Issue 1

The question remains as to why the two designs that went to consultation had very different junction designs, with Option 12 having three junctions, whilst Option 30 only one¹. It can be clearly seen from the scheme proposals presented for consultation², that Option 12 had additional junctions that were considered not necessary for Option 30. This was meant to be explained by the traffic expert during ISH2 Agenda Item 8, but it was not.

Figure 7. Option 12

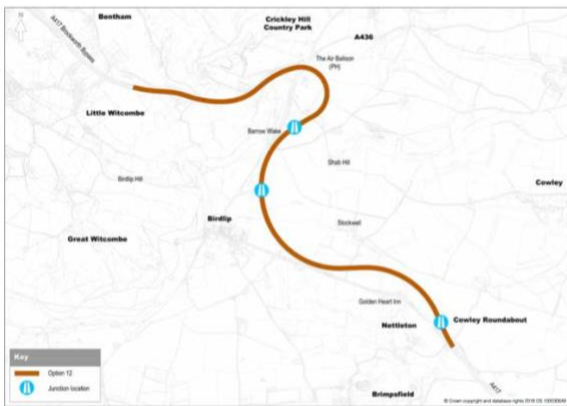
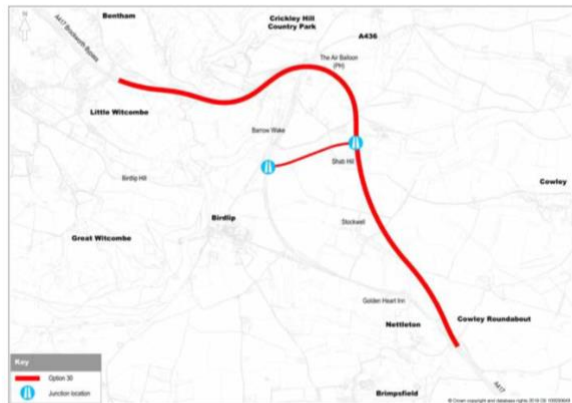
Question: Put simply, can the ExA be appraised as to why Option 12 had a junction at Cowley Roundabout in the design put forward for consultation, whilst it was assessed that Option 30 did not require it. The Applicant during ISH2 stated in response to the question raised that traffic modelling was 'extremely complicated' however it is hard to understand why any modelling would change this requirement at Chainage point zero along the route, other than to reduce cost!

Question: Can the ExA be appraised as to why the two designs prior to the consultation had marked differences in junction layout, given that it would be assumed the traffic modelling would have been the same?

Question: Can the ExA be appraised as to whether at the time of the consultation, if the junction layouts had been of similar number and design, would the monetised costs and benefits of both options have been more similar or even in favour of Option 12?
